Subject: Rezoning Petition Review

Date of Review: December 28, 2022 (**Revised January 26, 2023**)

Rezoning Petition #: 22-123

Location of Property: Approximately 39.02 acres located along the southwest side of Gibbon Rd, east of Statesville Rd and south of Old Statesville Rd.

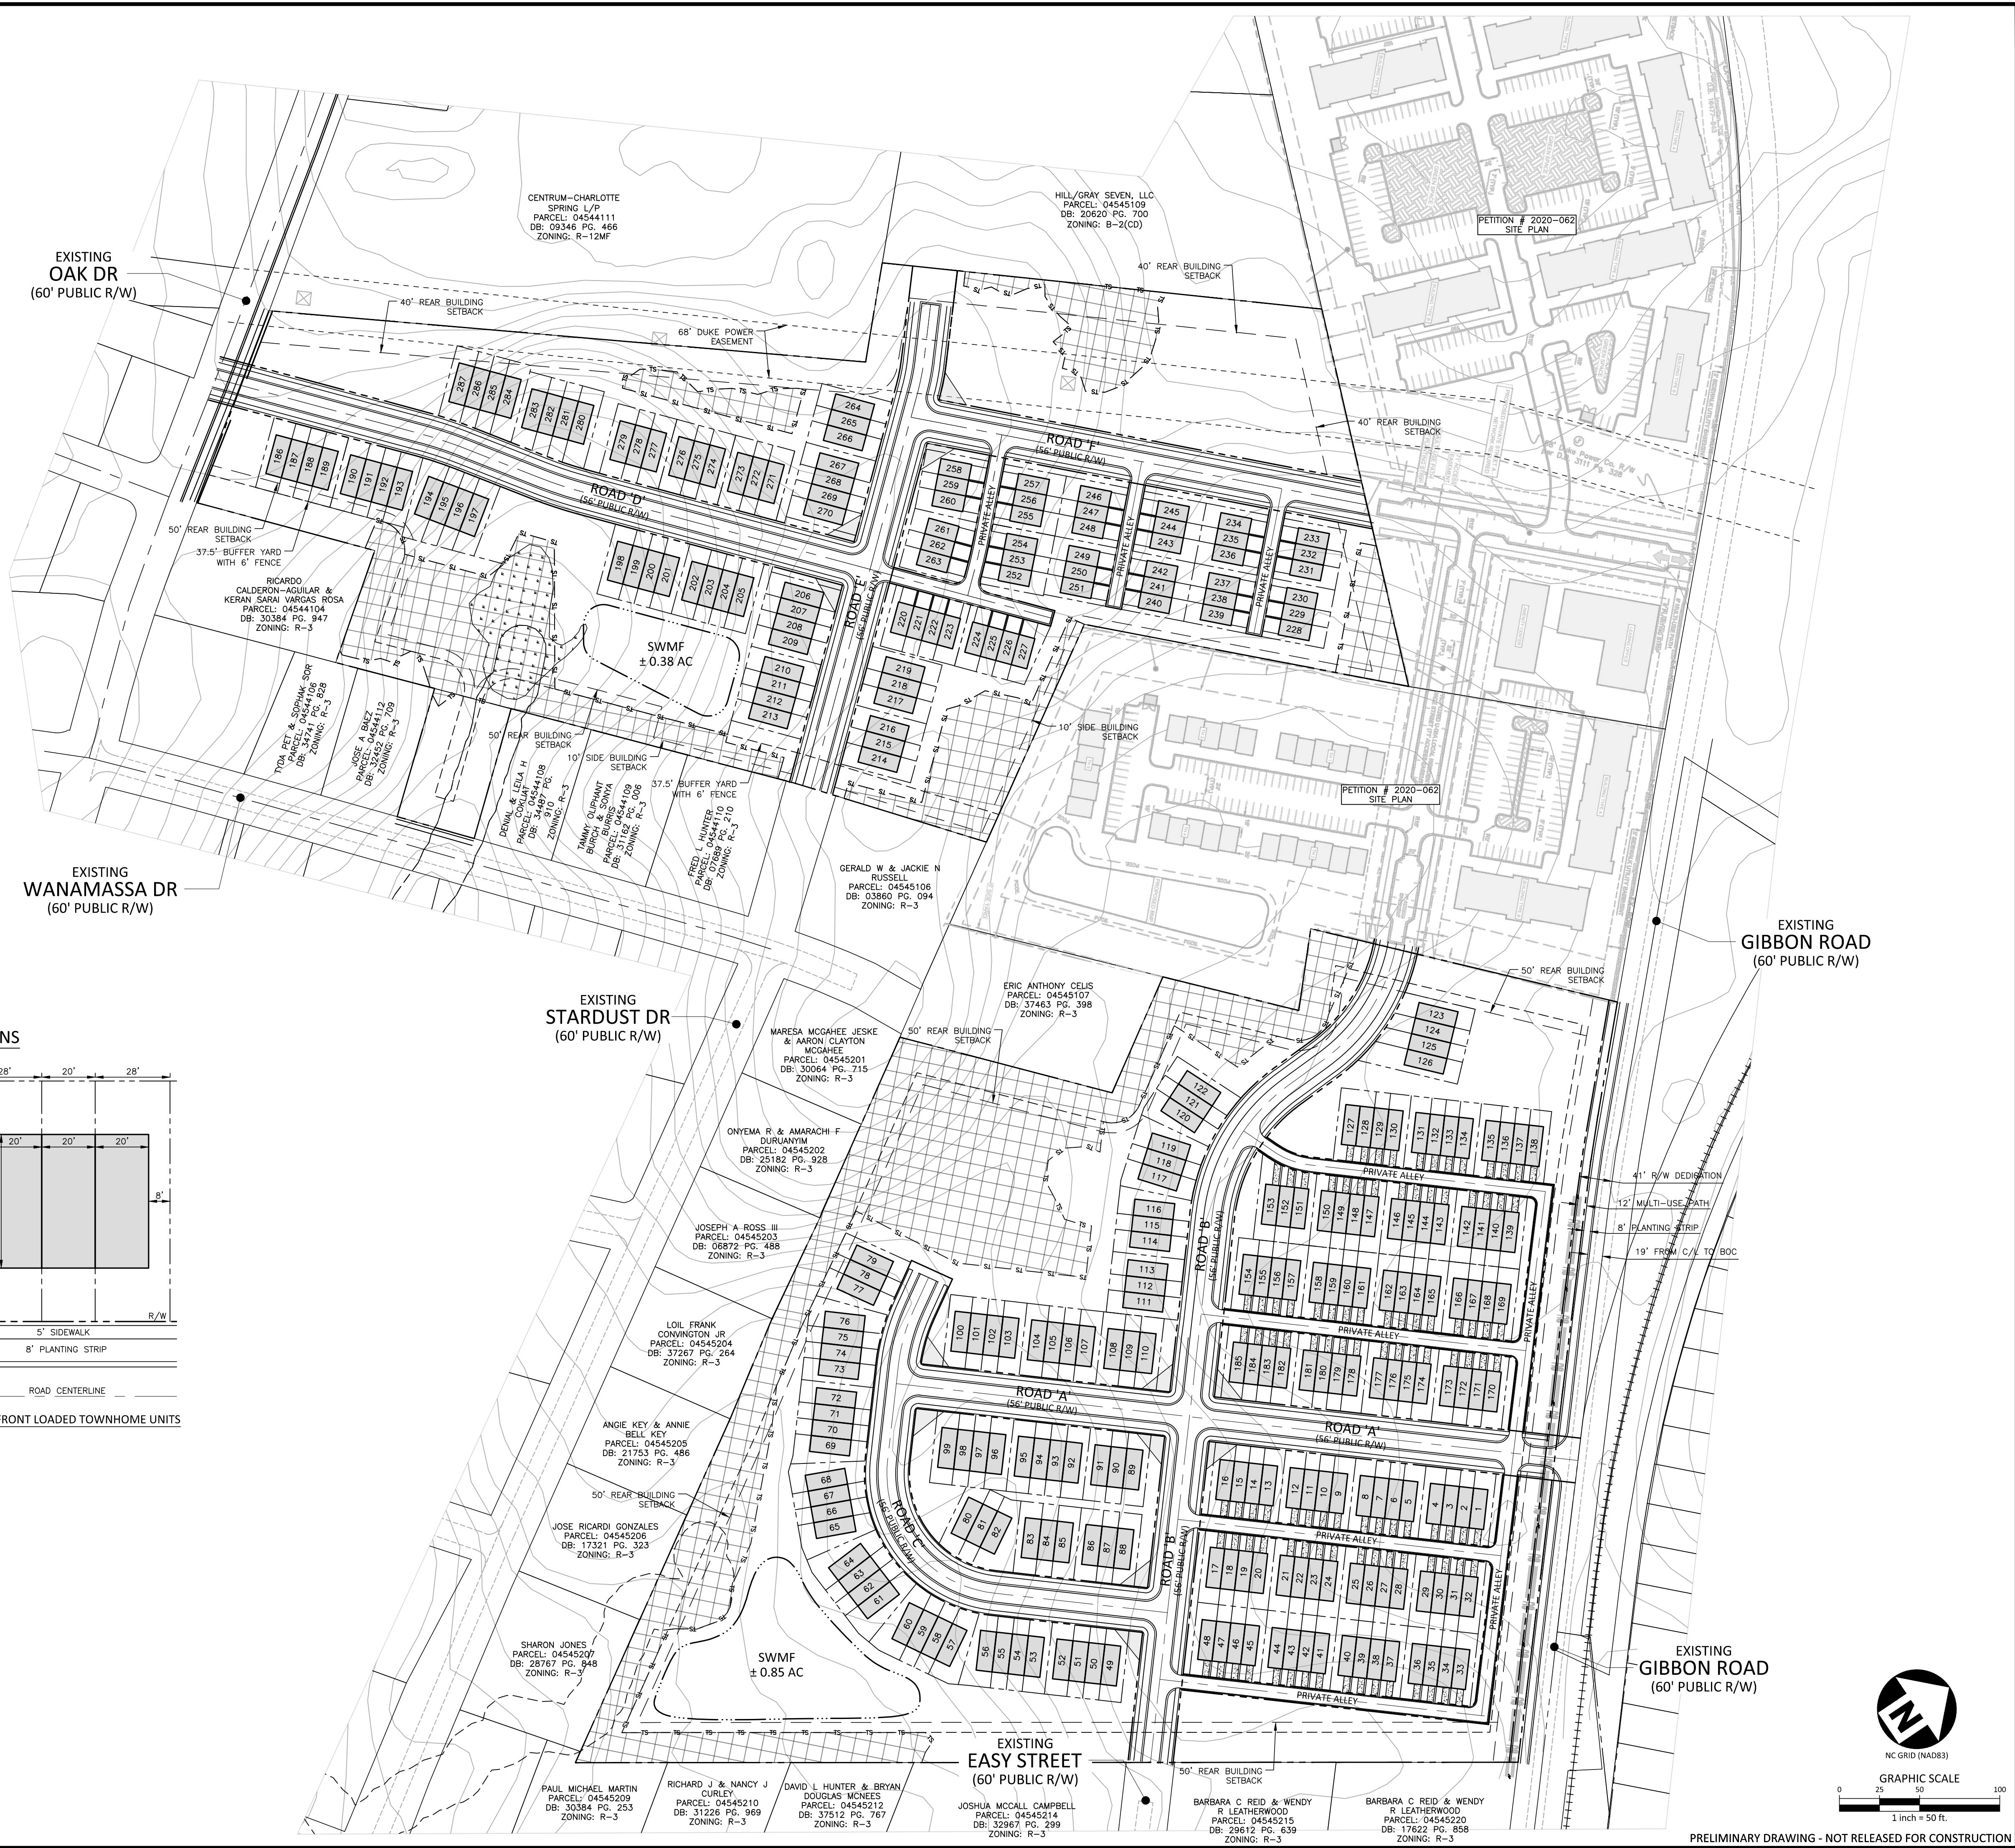
Downstream properties have Storm Water requests for service in areas of known flooding. Please include the following note under Environmental Features. *For adjoining parcels receiving storm water discharge the petitioner shall analyze the adequacy of the existing storm water conveyance on the adjoining parcels to Sampson Street. If the existing storm water conveyance on the adjoining parcels is found to be inadequate, the Petitioner shall make a good faith effort with the property owner(s) to improve the storm water conveyance or mitigate the storm water discharge onto the adjoining parcels.*
